EMBREY BUILDERS, LLC.

RFI

RFI #: 123
Date: 5/21/2012
Job: EB-02 Keller Springs Lofts
Phone: 877-777-6115

CC:
Subject: A2 & A2-SP Cased Openings

**A2-SP ONE BEDROOM/ONE BATH**  
SCALE 1/4"=1'-0"

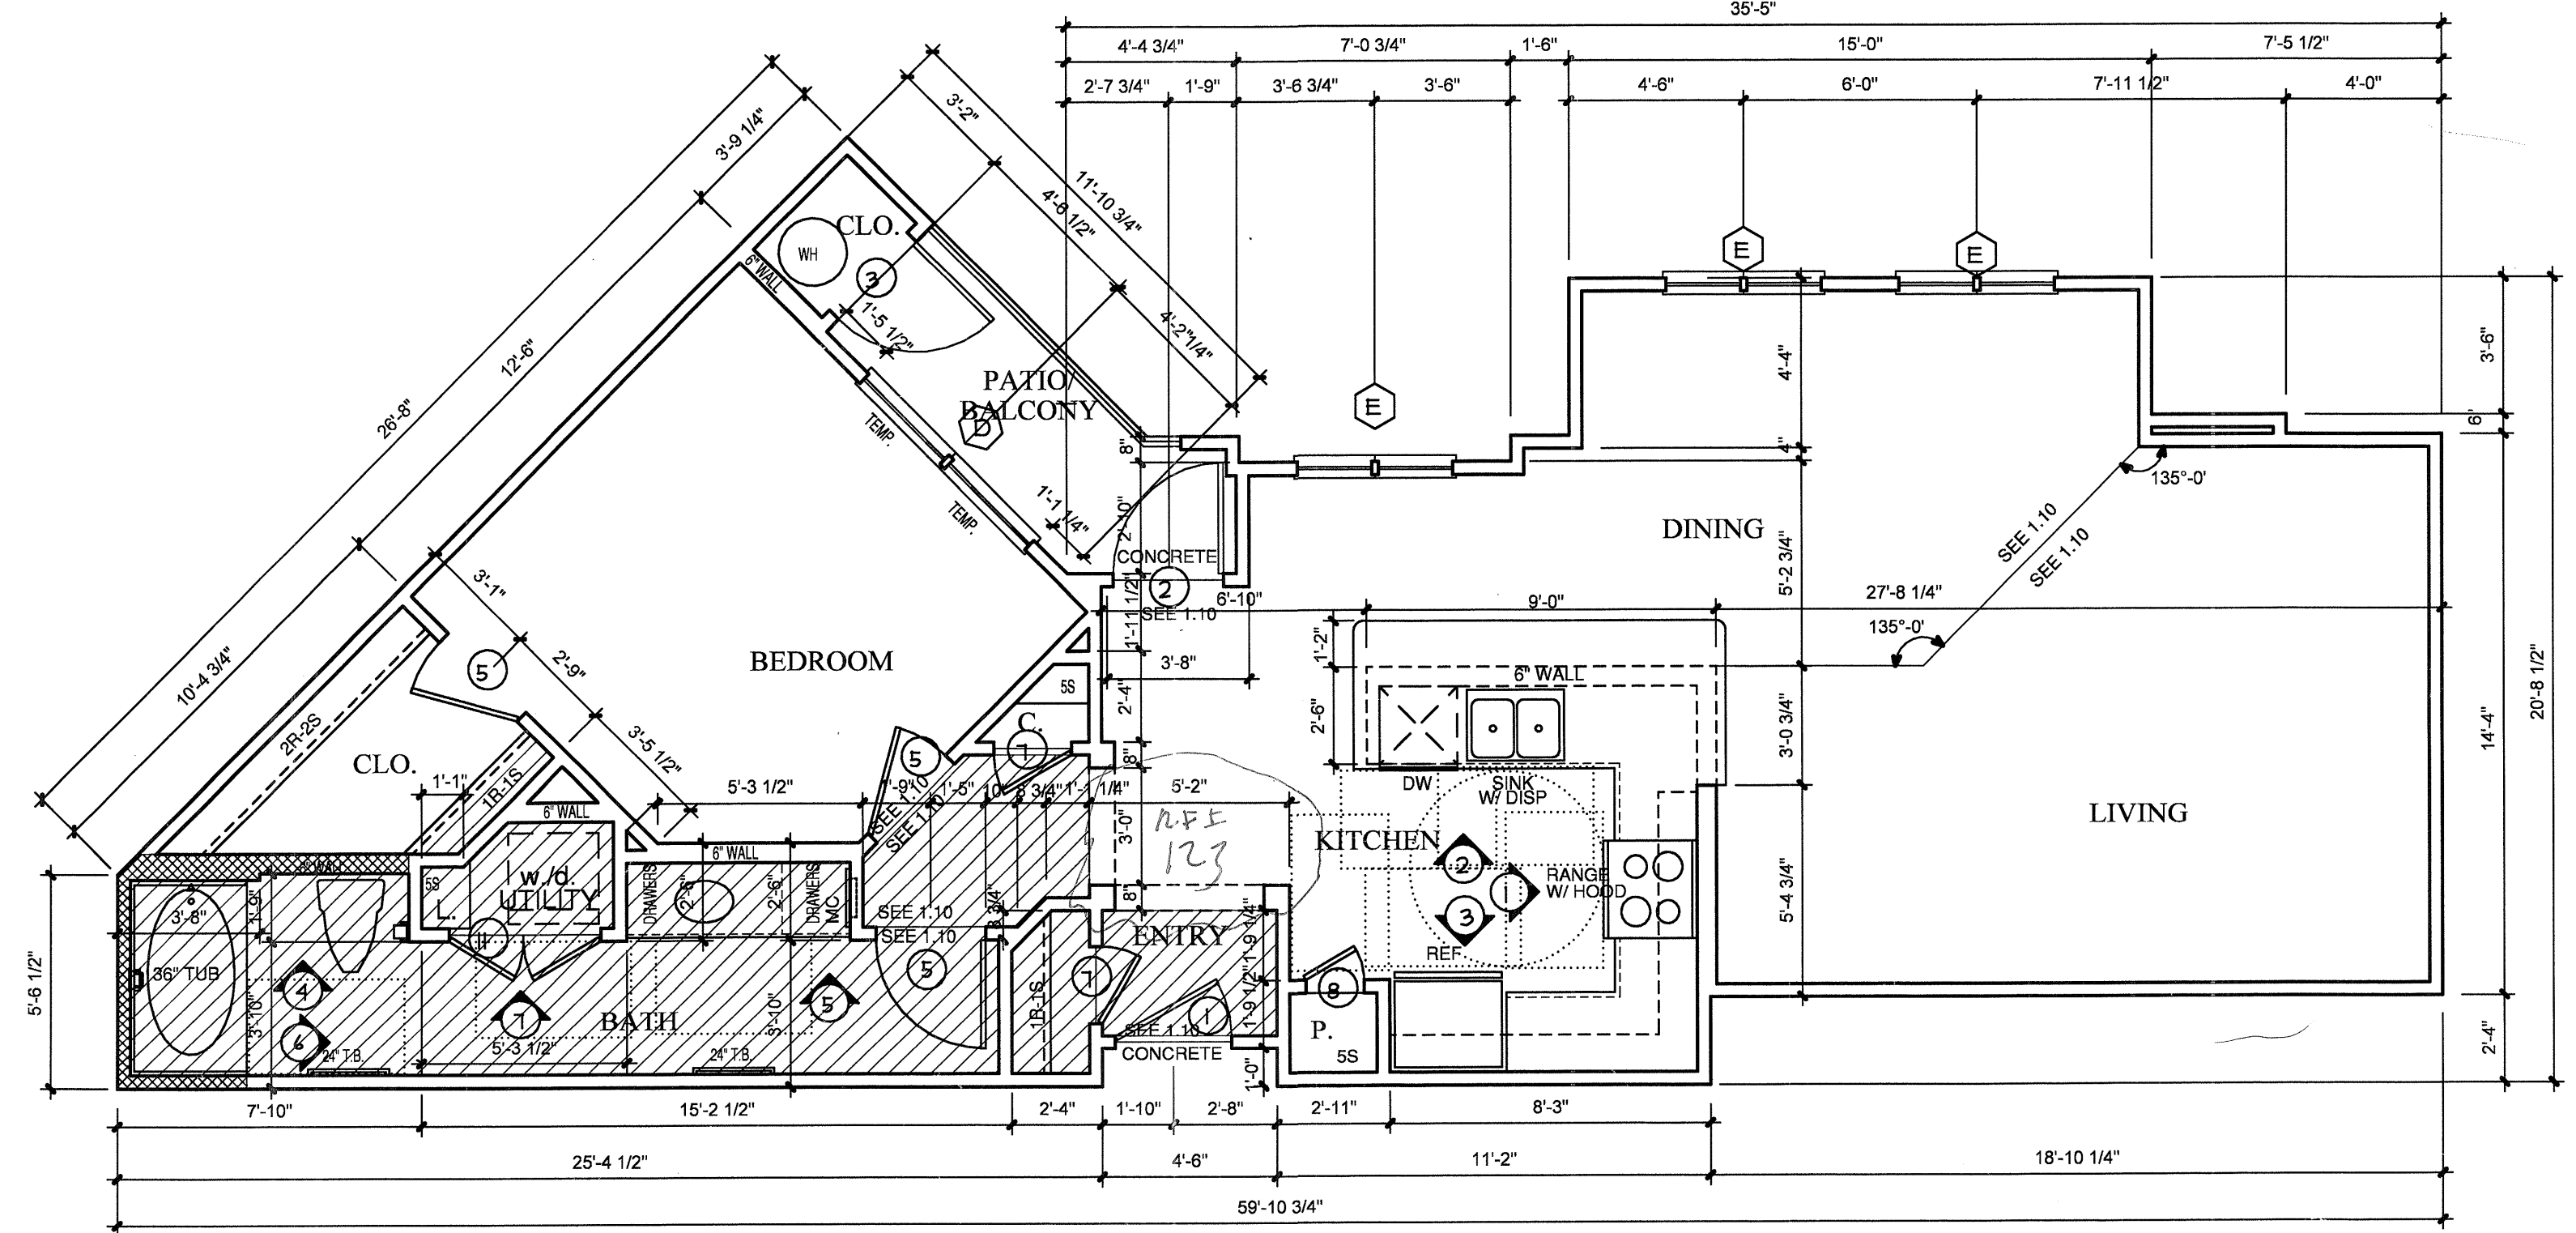
Request: Date Required: 5/29/2012
A2 Unit - A cased opening is called for between the LR and the hallway. Is this a wood cased opening? Please provide an elevation sketch to show height.
A2-SP Unit - Dashed lines are shown between entry and kitchen and between the kitchen and hallway. Are these cased openings? If so, please provide an elevation sketch showing opening heights.

Response: In both units, the cased opening is a flat opening at 6'-8" just like a door opening. Adding the wood casing is your option. BGO is fine with or without a door frame trim going around the opening.
